H22-0077-25

At Mondays meeting Weston Parish Council resolved to object to the planning application for twenty-four affordable homes at Weston Hills.

Weston Parish Council Objection

DRAWING NUMBER
622-S11-00-SI-SK-C-9000

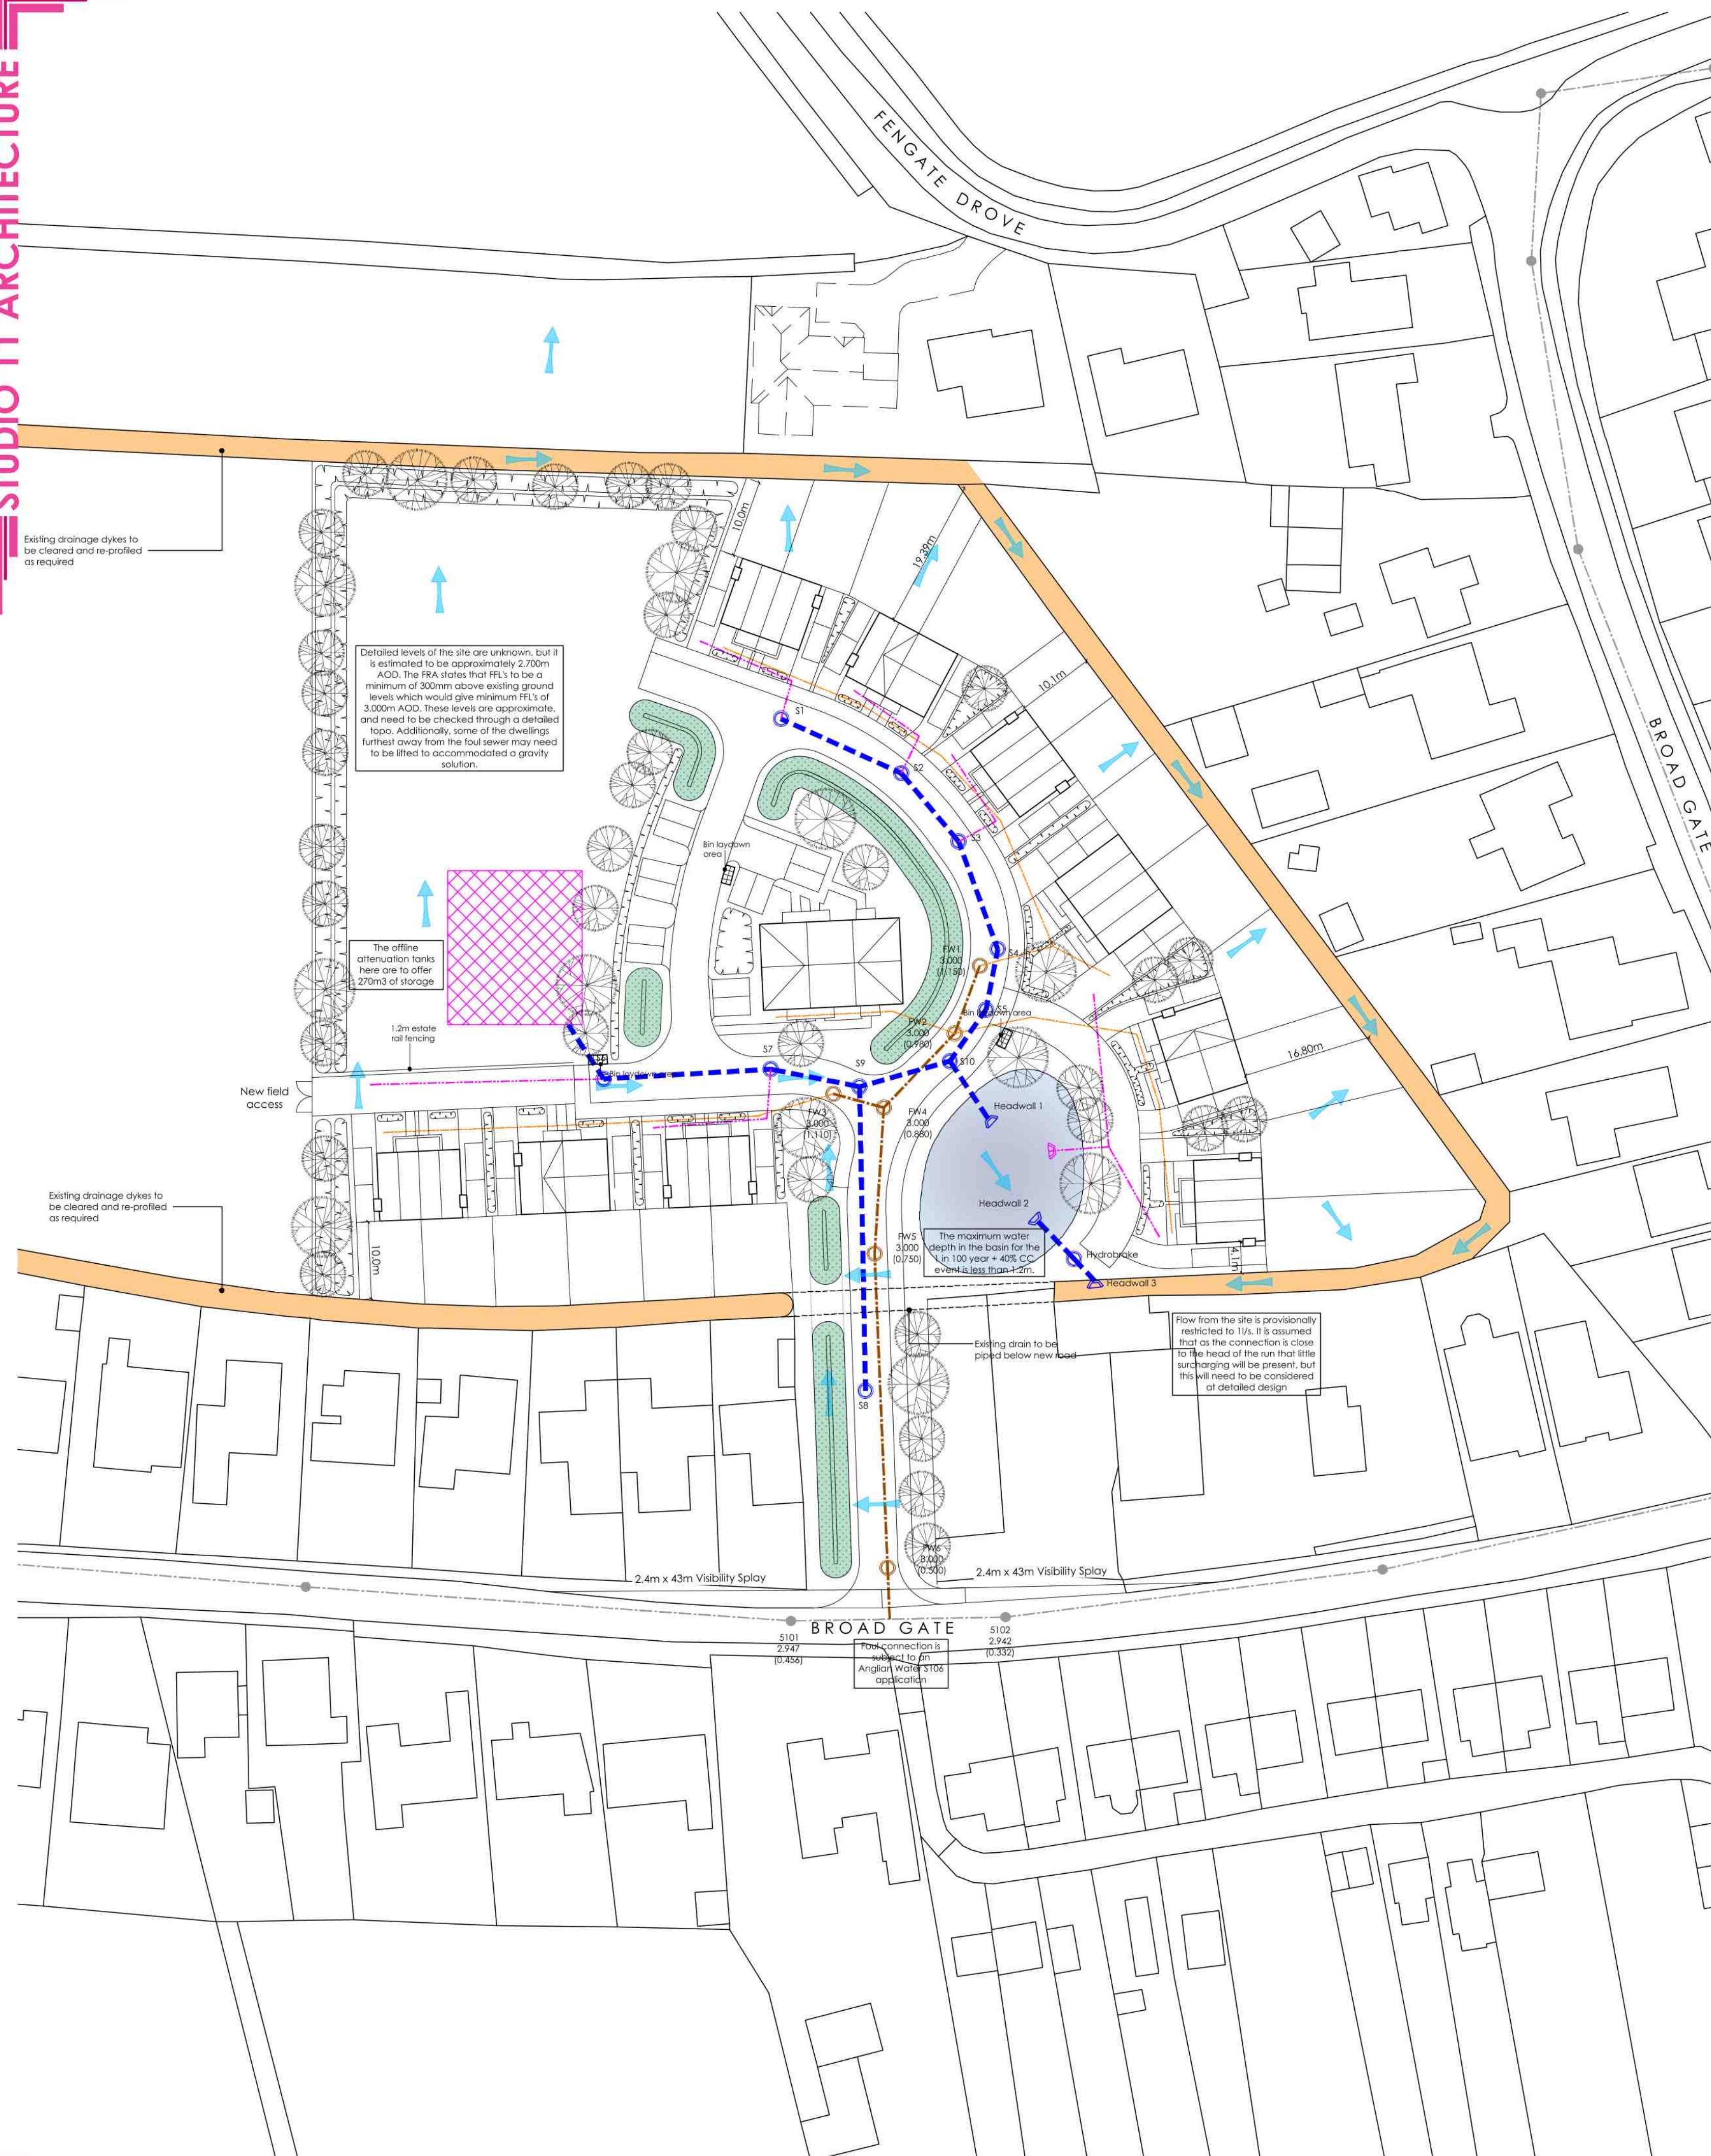
4 Drainage strategy and plan show surface water flows running in the opposite direction to actual existing flows.

DRAWING NUMBER
622.PD.P3.01

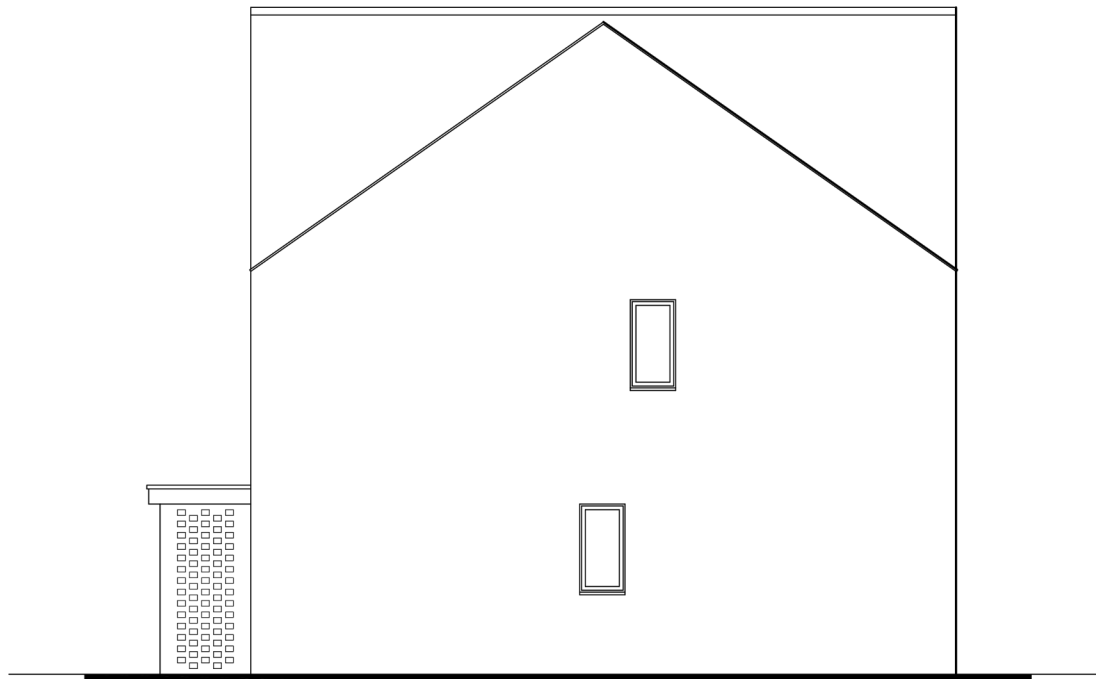
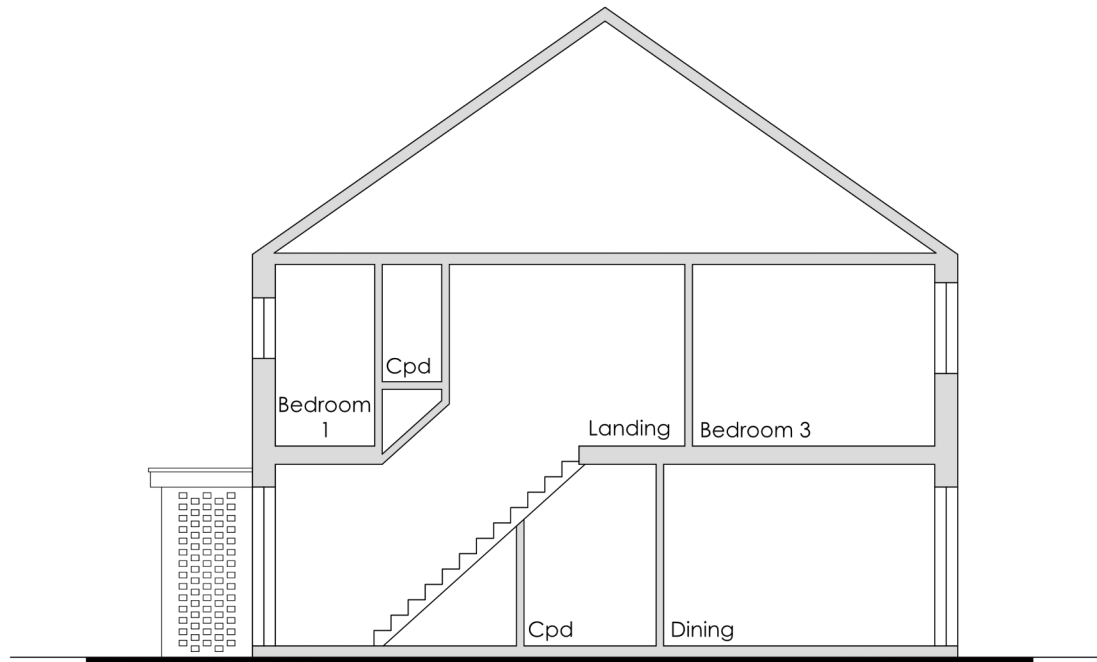
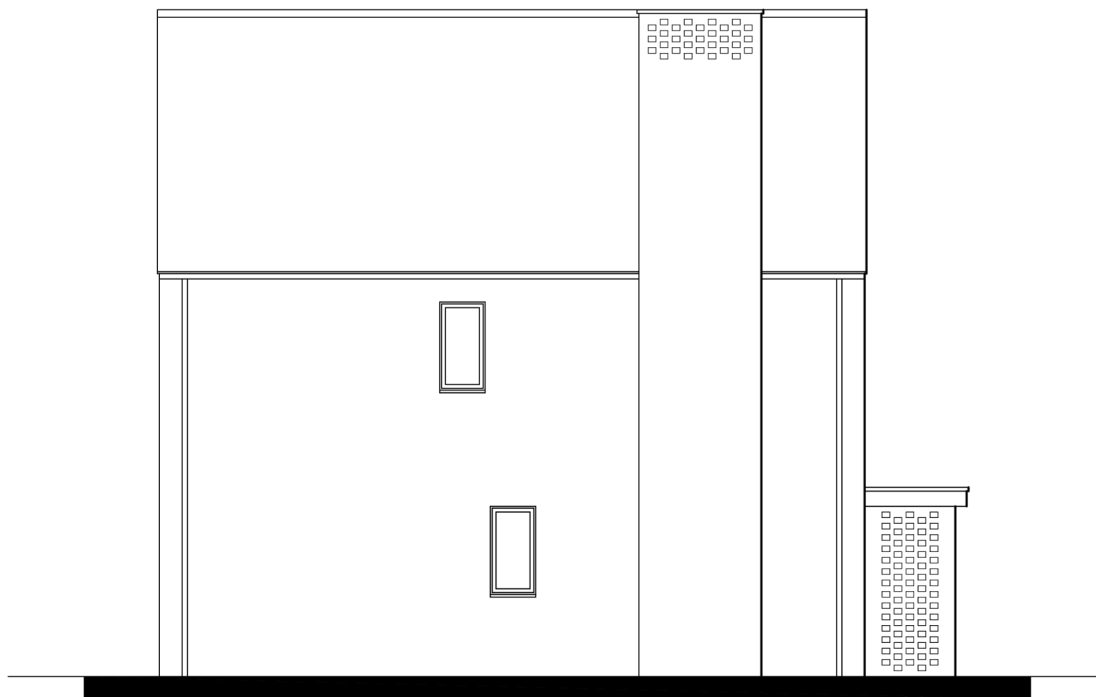
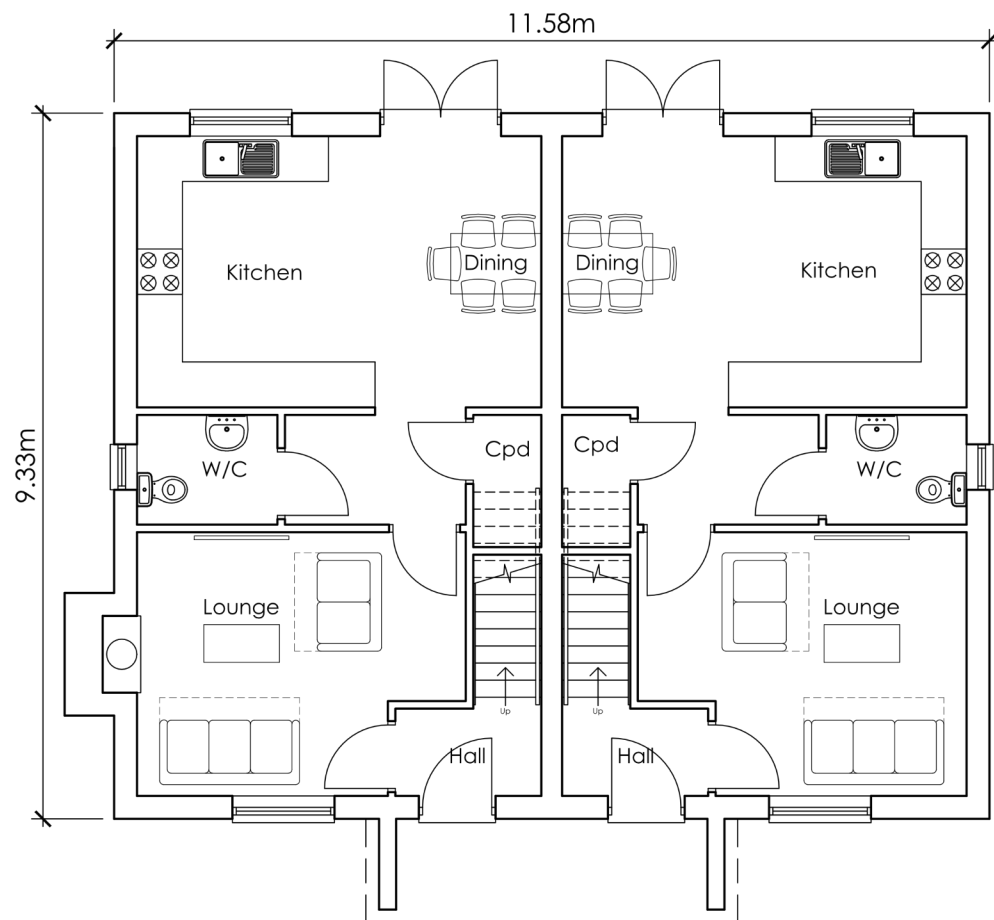
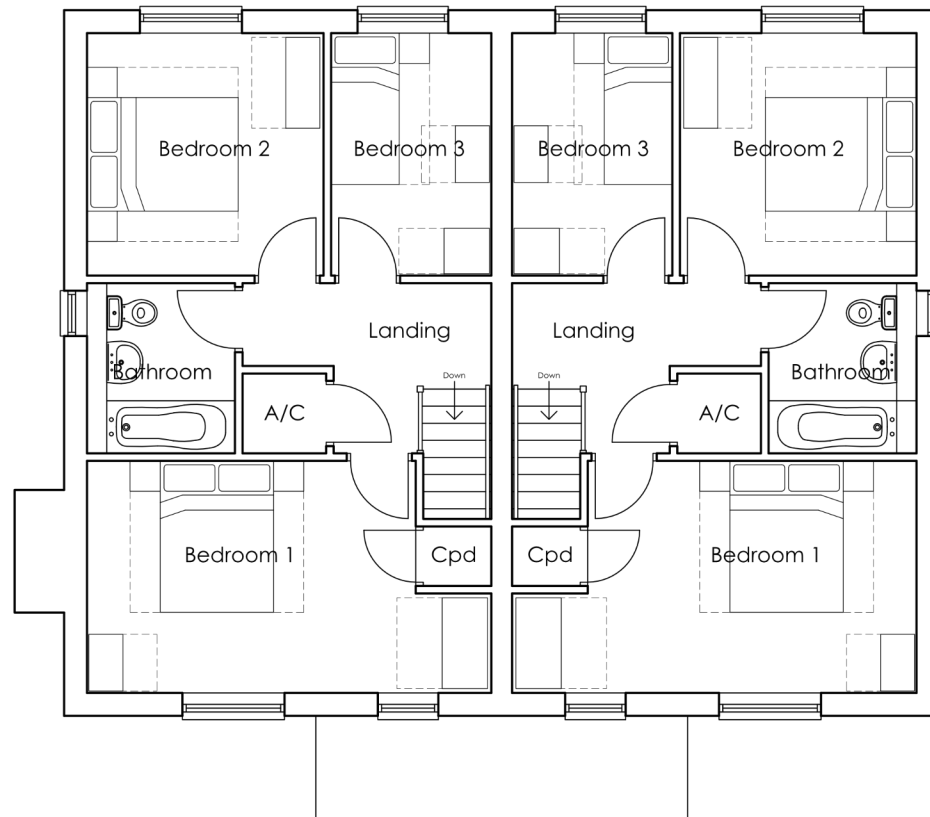
7 Incompatible with the local pattern of development (ribbon/linear frontage homes), and design of existing homes. House designs are bland - all the same materials and design – 2 storey, gabled ended, with Bronze windows and zinc downwater goods. No height transitions, bungalows, to be in keeping with the existing dwellings in the village. In conflict with the character of the area.
